STATEMENT OF RESPONSE TO PRE-APPLICATION CONSULTATION OPINION

BUILD-TO-RENT RESIDENTIAL AND COMMERCIAL DEVELOPMENT FORMER CHADWICKS SITE, GREENHILLS ROAD, WALKSINTOWN, DUBLIN 12

MARCH 2022

SUBMITTED ON BEHALF OF: Steeplefield Limited 32 Molesworth Street, Dublin 2.

1 BLOCK C- PROPOSED NORTH ELEVATION

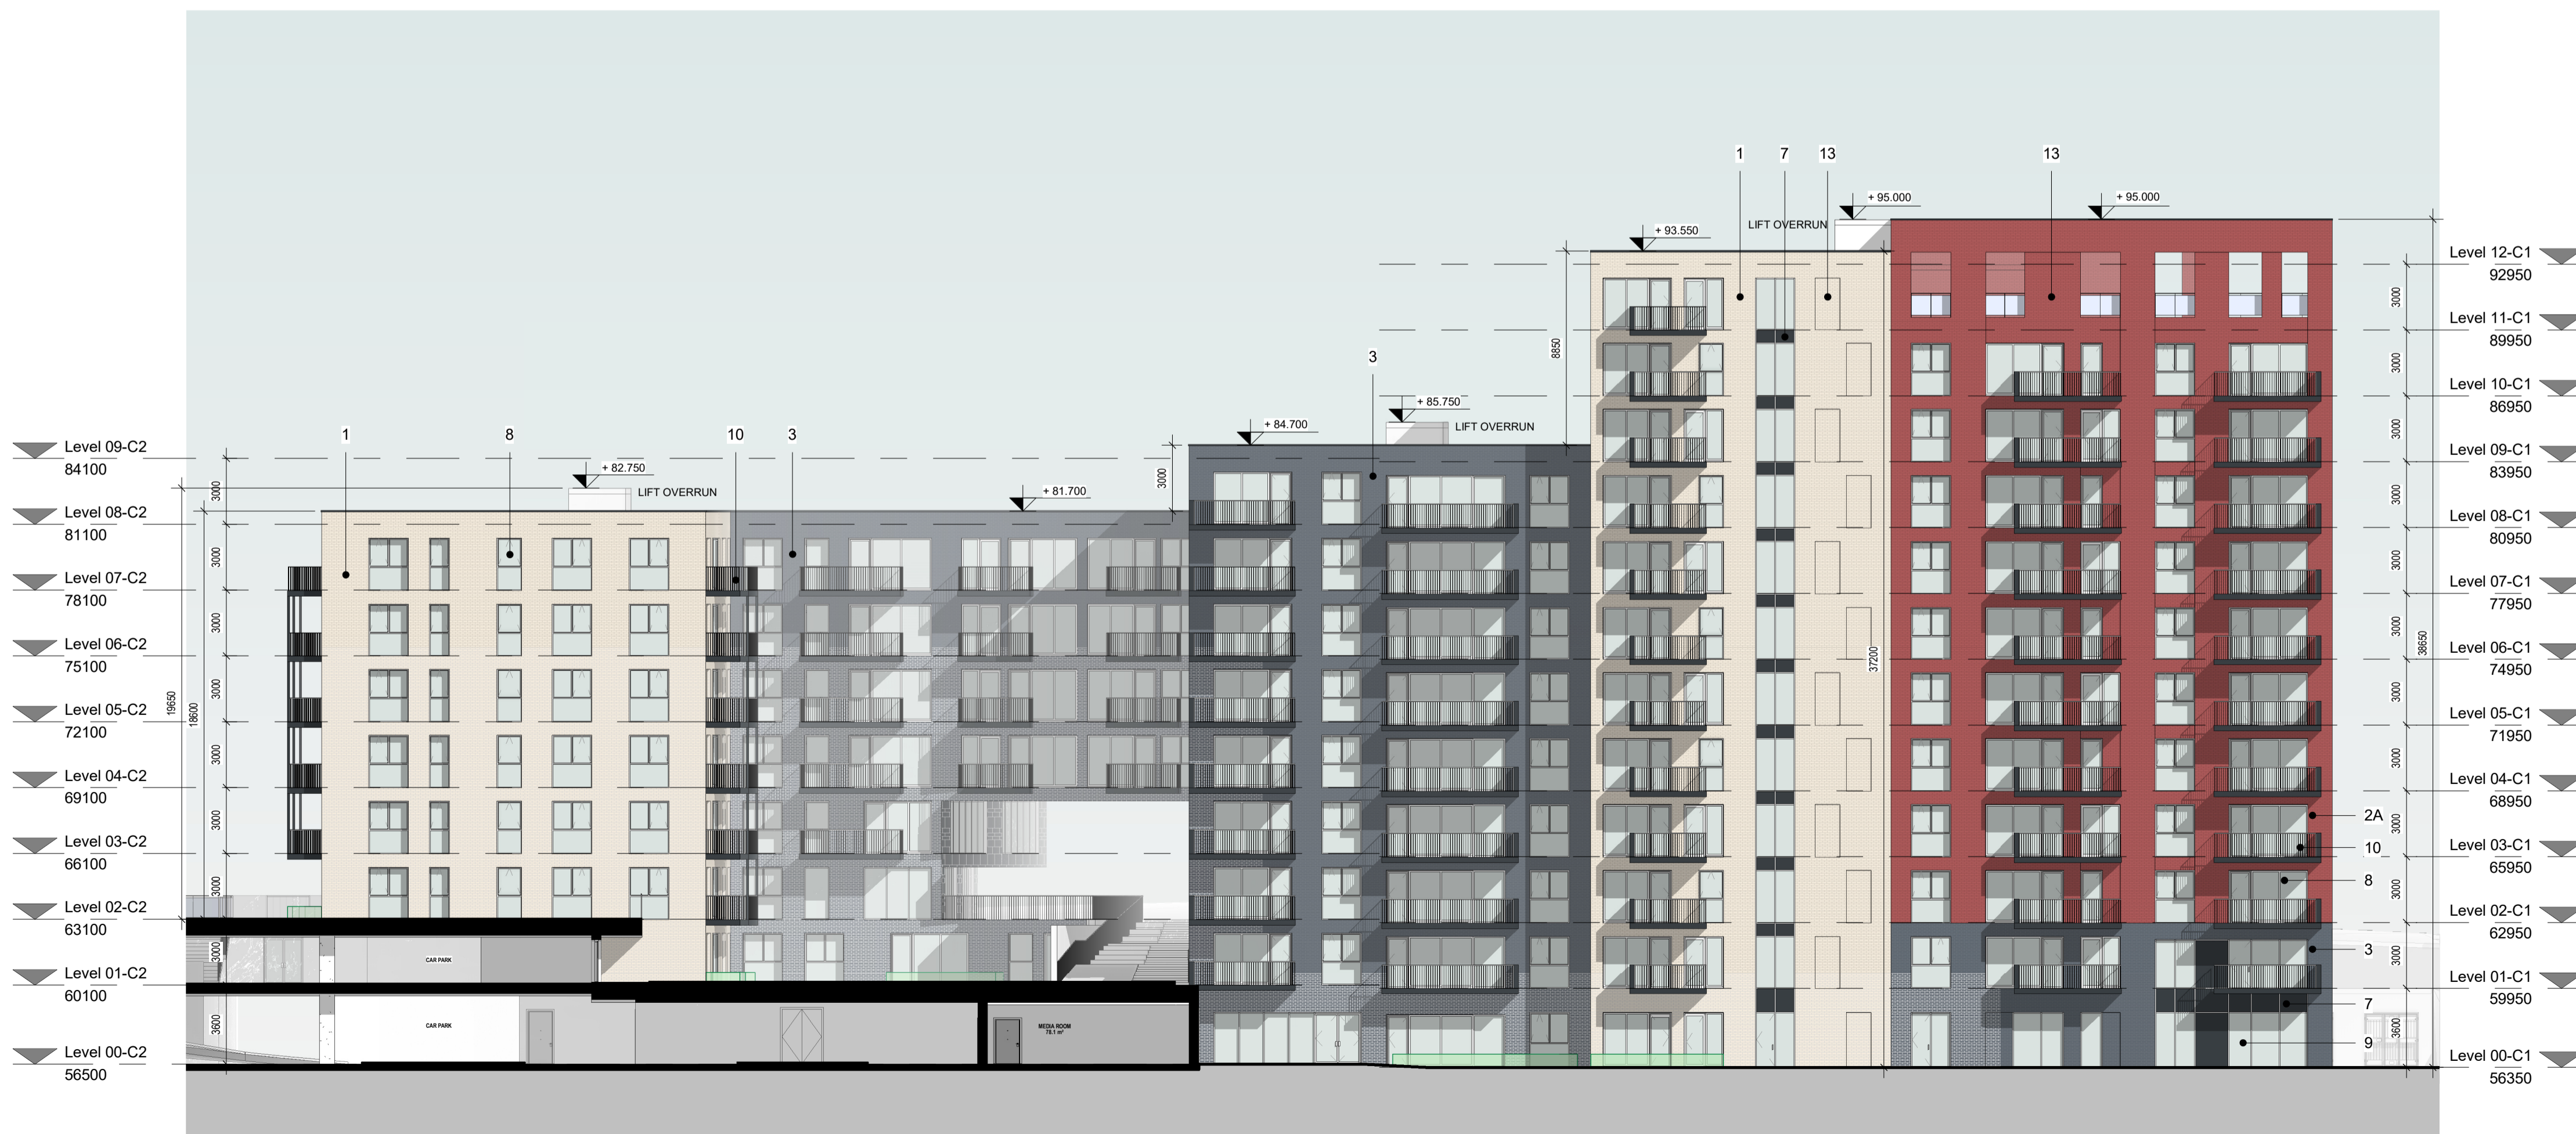
• A stronger street edge is required on Greenhills Road in response to the wayleave.

The Design Team has revisited the design of the development fronting Greenhills Road to better align with the objectives of the City Edge Project. A portion of Block C fronts the road, providing 2 no. retails units and a hardstanding public plaza, providing much-needed addition to the public realm in the area. It is considered difficult to provide frontage along with the remainder of the boundary due to the location of a water main and its associated wayleave which runs along the northern boundary of the subject site.

In discussions with the design team, Irish Water has confirmed that they do not intend to relocate the water main. It was suggested that it might be moved as part of Bus Connects works in the area, but this is not the case. Therefore, no buildings can be added along much of the frontage with Greenhills Road as shown on the Site Location Map by the yellow wayleave in favour of Irish Water.

A strong street frontage will be provided along the road to the south, with the proposed creche, commercial units and residential amenity spaces in front of a newly installed footpath, cycle lane and landscaped public realm. Pedestrian access to the buildings and access through the site will also be available along both street frontages, thus improving the animation of the streets.
